Rezoning Transportation Analysis

Petition Number:2020-033

General Location Identifier: Tax ID 15510337

Date	Description
04-02-20	First Review
05-20-20	Second Review

SHEET TITLE
RZP-2020-033
RE-ZONING
SITE PLAN

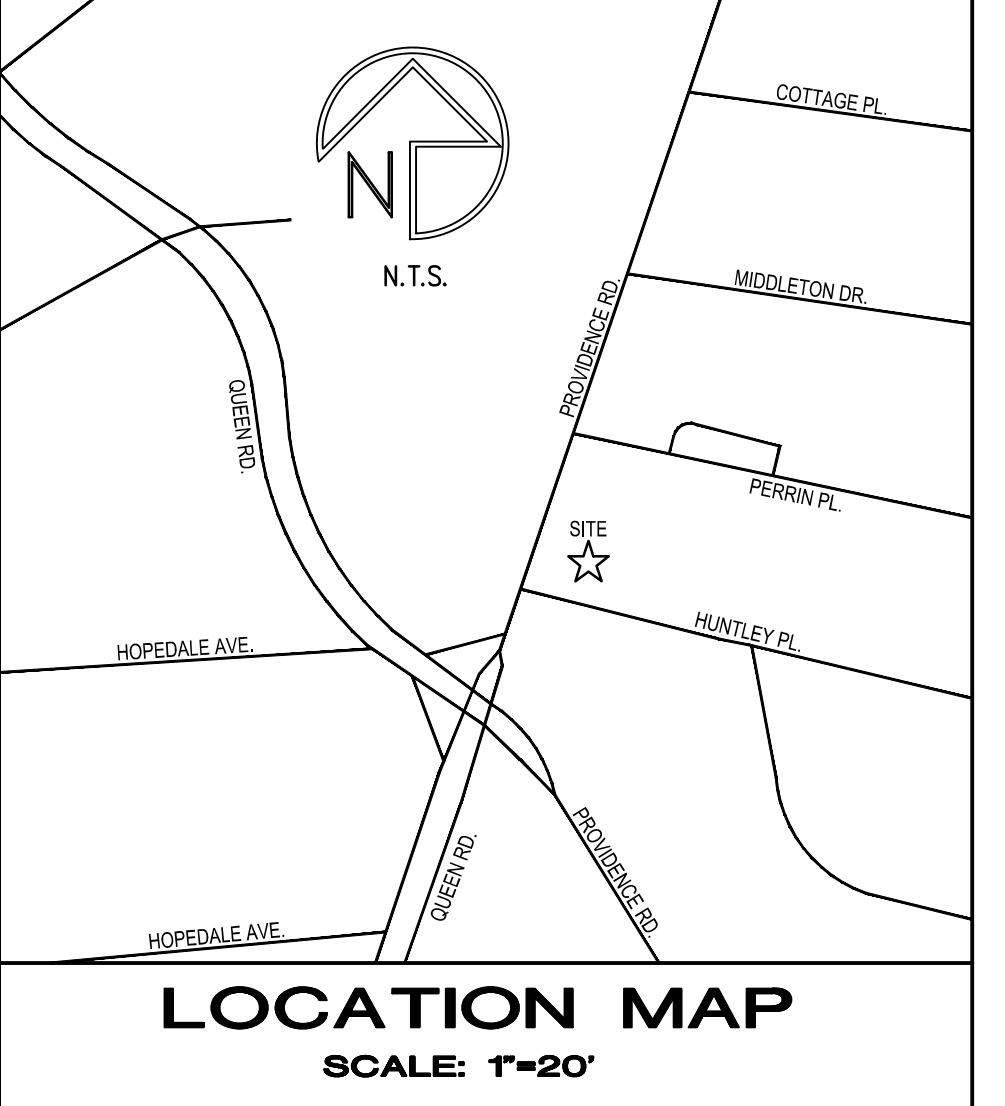
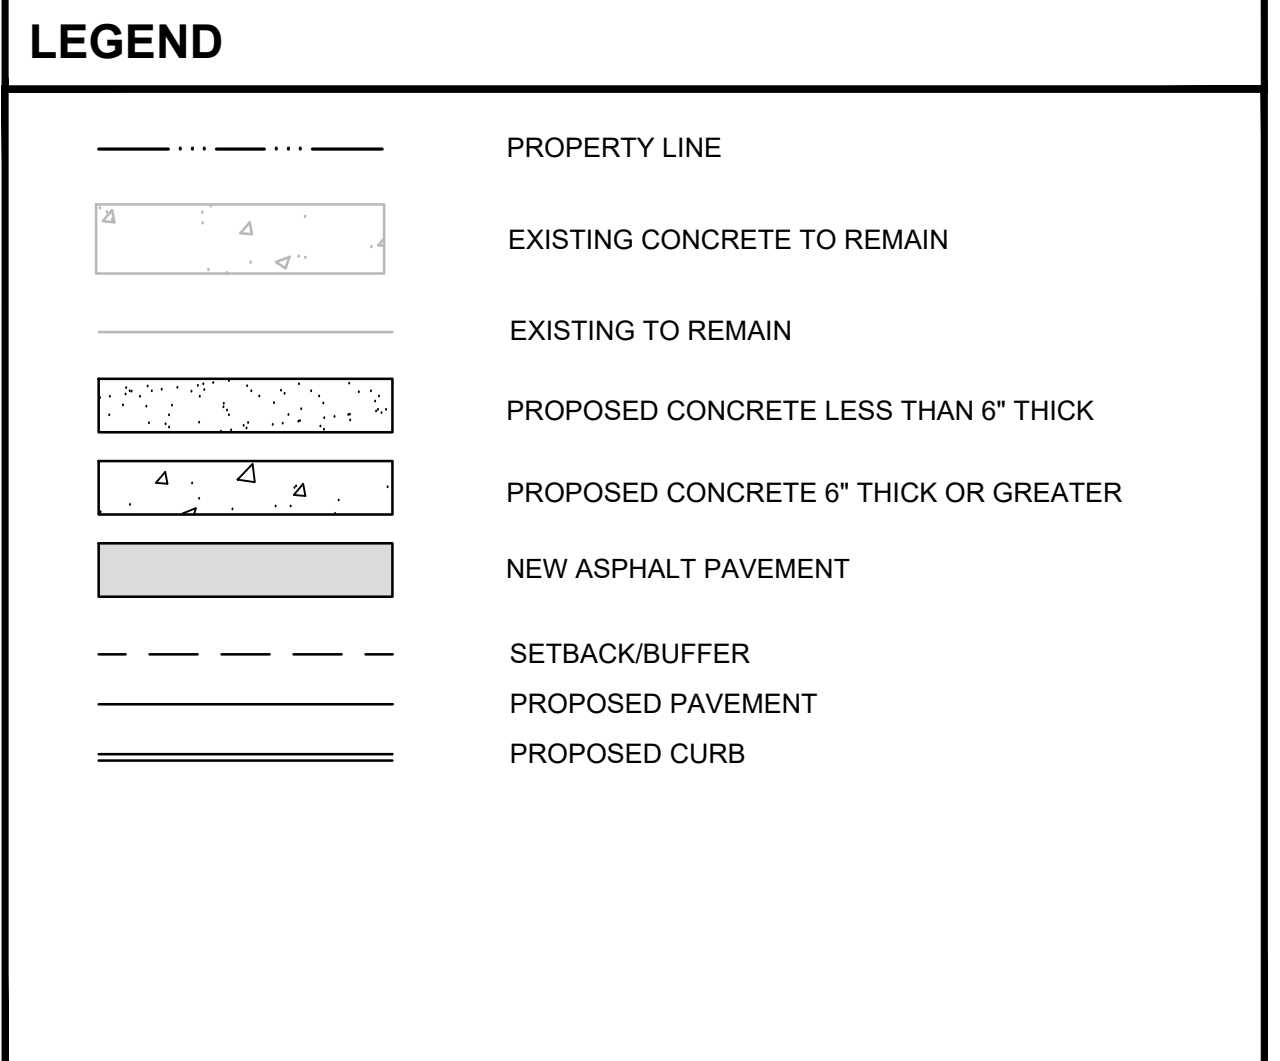
The site is located on a state-maintained major thoroughfare. The site plan is committing to an 8-foot planting strip and 12-foot multi-use path. CDOT continues to request a sidewalk transition on sidewalk along Providence Road.

8. **(Revised Plan 05-13-2020)** Petitioner should revise the site plan to provide a sidewalk transition prior to the curb ramp at the intersection of Providence Road and Huntley Place.
